**WELWYN HATFIELD BOROUGH COUNCIL
EXECUTIVE DIRECTOR - PLANNING, PUBLIC PROTECTION AND GOVERNANCE**

DELEGATED APPLICATION

Application No: 6/2018/1153/FULL
Location: 8 Harpsfield Broadway Hatfield AL10 9TF
Proposal: Change of use of property from shop (A1) to ice cream/dessert parlour (A1/A3) and erection of single storey rear canopy seating area
Officer: Mr William Myers

Recommendation: Refused

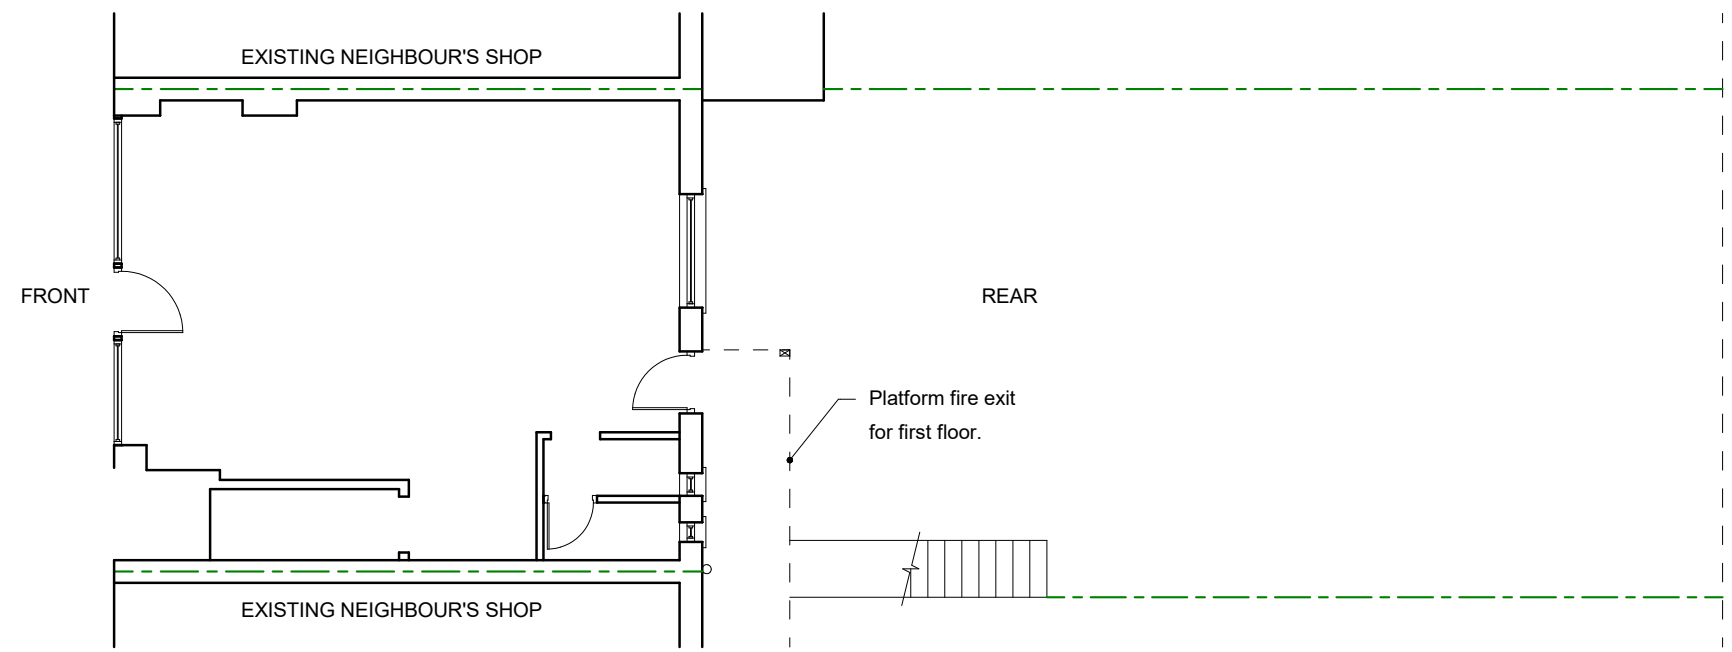
<p>Any other considerations including preserved or enhanced character or appearance of Conservation Area</p>	<p>It is note that the Council's Public Health and Protection team has raised concerns about the location of the customer toilet that is proposed within this application because they consider that the current arrangement could result in a risk to human health. As a consequence of this it is considered that the current floor plans for the proposed use would result in an unacceptable arrangement for the proposed use. If it were to be considered that the proposed development were acceptable it is considered that in accordance with the advice from the Public Health and Protection team that the current arrangement of the toilet be changed so as not to create a potential risk to human health.</p>
<p>Conclusion</p>	
<p>The proposal is considered to be in conflict with Policy TCR25 of the adopted Welwyn Hatfield District Plan 2005 and the emerging Policy SADM4 of the Welwyn Hatfield Draft Local Plan Proposed Submission August 2016 and the relevant policies contained in the National Planning Policy Framework 2012.</p>

DRAWING TITLE:
 PROPOSED ELEVATIONS AND
 PROPOSED SECTION.

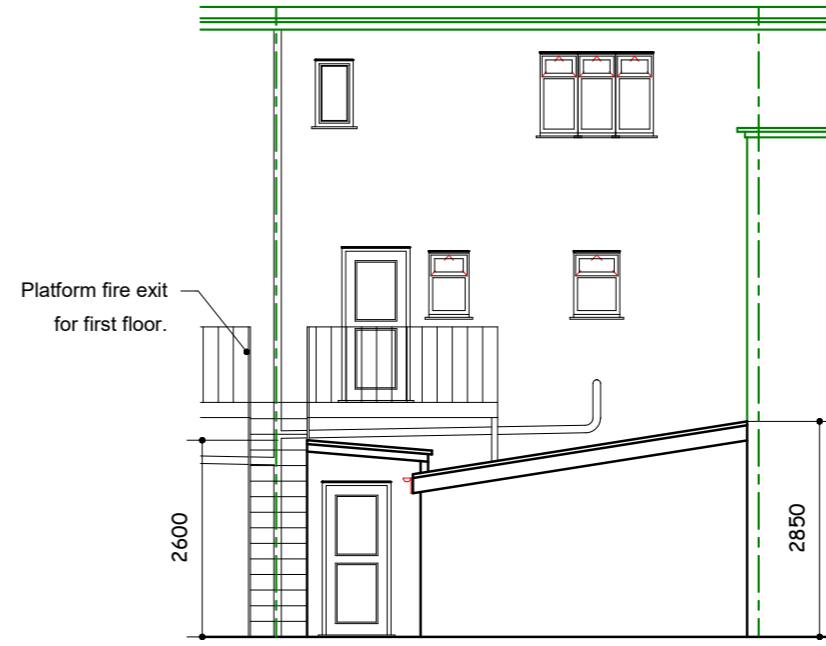
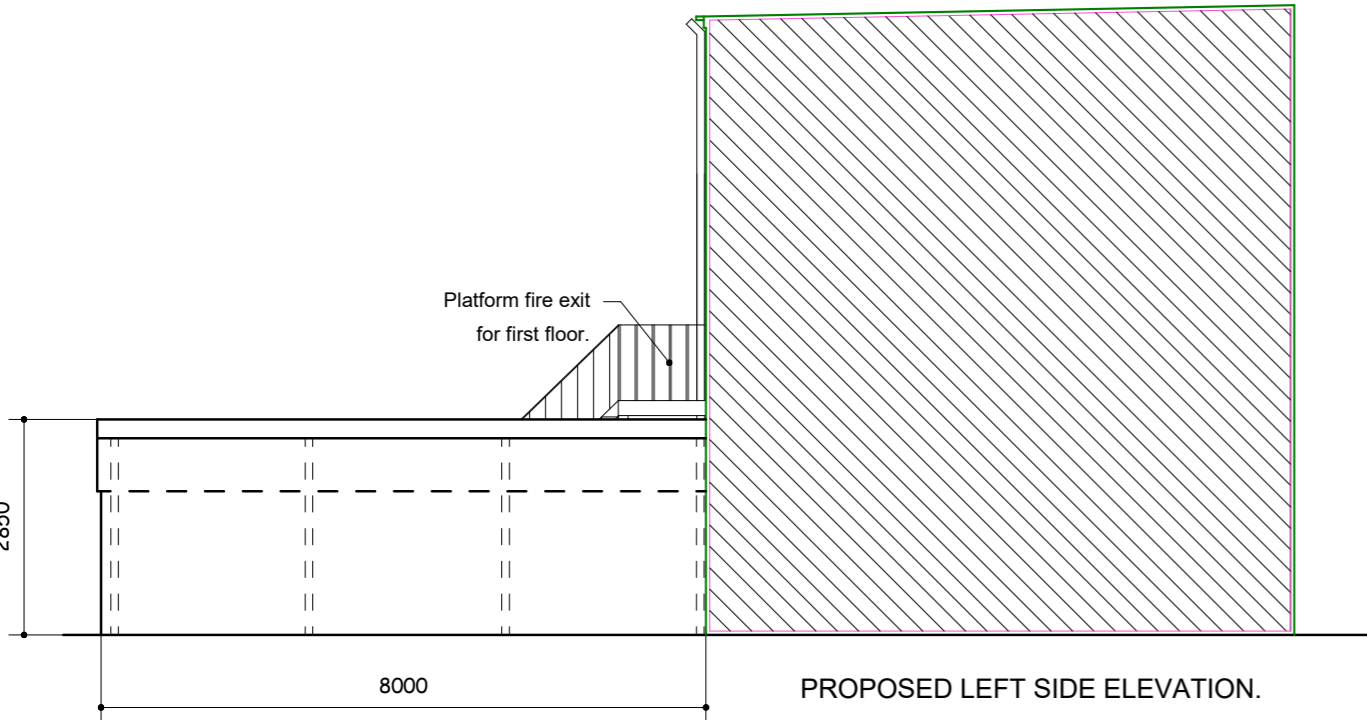
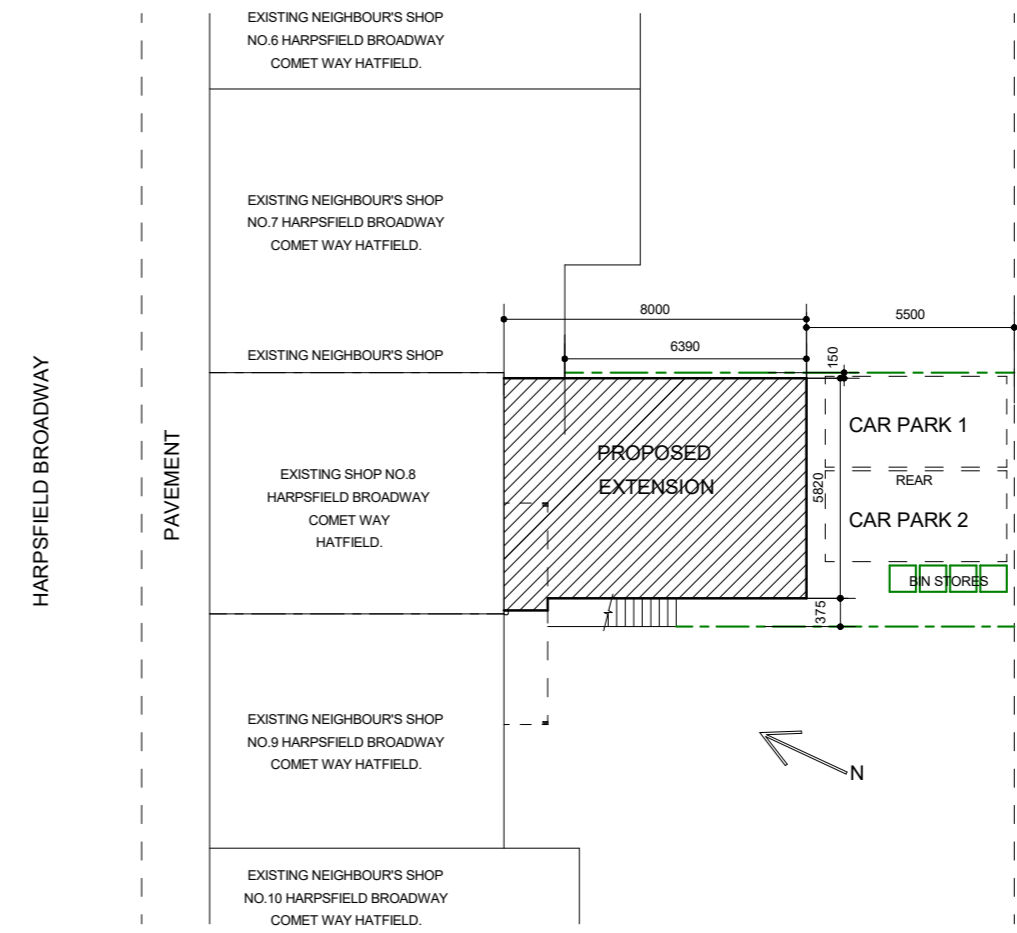
<p>development would be unlikely to harm vitality or the viability of the centre and would as a result meet criterion (iii).</p> <p>Overall, the proposed change of use would fail to meet all the criteria within both Policy TCR25 of the District Plan 2005 and Policy SADM4 of the Emerging Local Plan 2016. Furthermore, as no information has been provided to demonstrate an exception for why these policies should be overridden in the case and no documentation has been provided to demonstrate that there is a lack of demand for an A1 retail use in this location which should be evidenced through an active and extensive marketing of the unit for at least 12 months, there is no reasonable justification in this case to diverge from both the Council's existing and emerging policy in this area.</p>
<p>Design (form, size, scale, siting) and Character (appearance within the streetscene)</p>	<p>Local Plan Policies D1 and D2 aim to ensure a high quality of design and to ensure that development respects and relates to the character and context of the locality, maintaining and where possible enhancing the character of the existing area. These policies are expanded upon in the Council's Supplementary Design Guidance (SDG) which requires the impact of a development to be assessed giving regard to the bulk, scale and design of the proposal and how it harmonises with the existing building and area. These objectives are broadly consistent with a core principle of the National Planning Policy Framework (NPPF) which states that good design is a key aspect of sustainable development, is indivisible from good planning, and should contribute positively to making places better for people.</p> <p>In addition to this application being for a change of use of the premises it also seeks permission for the construction of a single storey rear extension to the unit. The information provided on the plans for this proposed extension are limited with the result that it is unclear whether the proposed structure would be fully enclosed, what materials it would be constructed out of and what the proposed extension would be used for. As a consequence of this it is difficult to undertake a meaningful assessment of the proposed extension. It is therefore considered that if this application were recommended for approval further information would need to be submitted by the applicant to indicate whether the structure would be enclosed or open, what materials it would be constructed from and what it would be used for.</p> <p>In terms of the depth, size and height of the projection it is not considered that this would be unacceptable or out of character given the size of rear extensions that have been constructed to the rear of other retail/commercial unit within Harpsfield.</p>

<p>Impact on neighbours</p>	<p>Given the limited information that has been provided about the appearance of the proposed structure a full analysis of its impact on neighbours cannot be undertaken. Having said this, it is considered that in principle an extension of this side could be acceptable because the land to the rear of this unit, and the other commercial units, is used primarily for deliveries of good and storage of equipment associated with the businesses.</p>
<p>Access, car parking and highway considerations</p>	<p>It is not clear from the proposals whether the proposed parking provision would result in a change in the parking provision which currently exist on the site. As the proposed development would result in a change of use of the premises it is considered that parking provision for the proposed mixed use should be assessed.</p>
